Application number: 2021/92462	
What is the application for?:	Outline application for erection of detached dwelling
Address of the site or building:	rear of, 1091, Manchester Road, Linthwaite, Huddersfield, HD7 5LS
Postcode:	HD1 4QT

Type of comment: An objection	
Do you wish your comments to be published on the website anonymously?	No

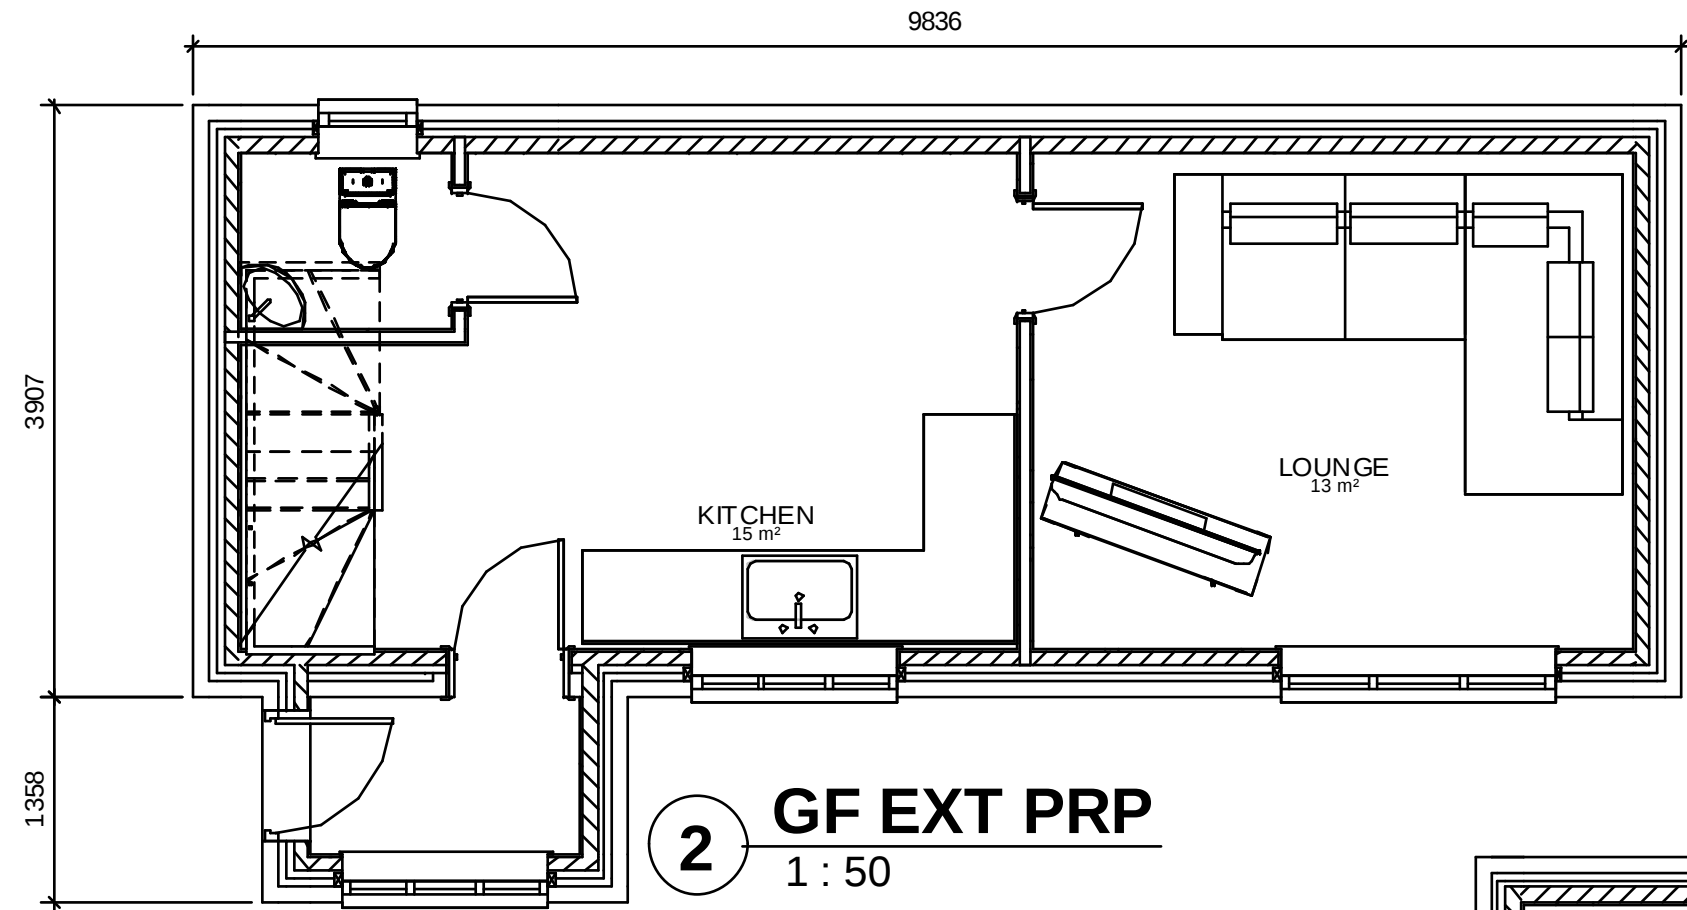
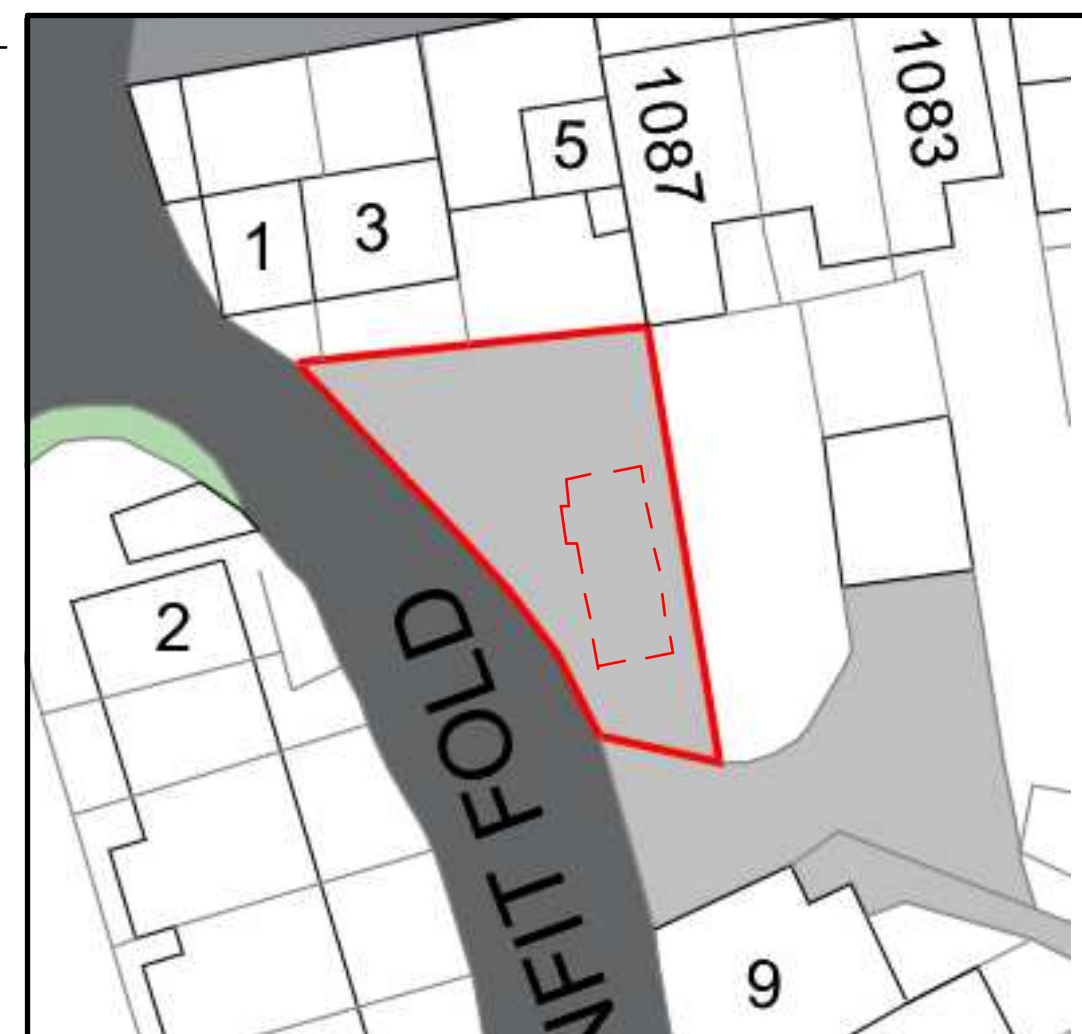
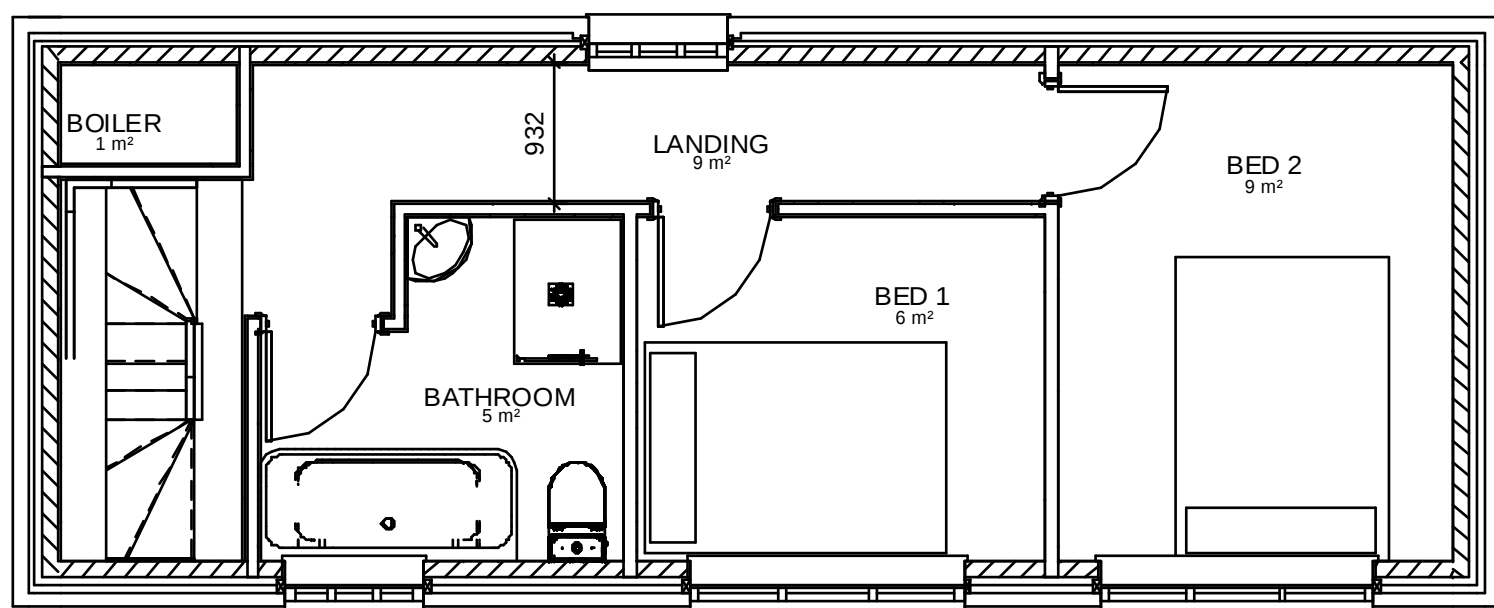
The proposed development, would largely be built of artificial building materials, it would not fit in with the other properties in the Fold, as they are built of Yorkshire stone. It would be out of character in the setting.

The house and the flat pictured, in the heritage statement, (which are both owned by the proposer), the tenants of these properties and their neighbors, would have no privacy and would be overshadowed by the dwelling.
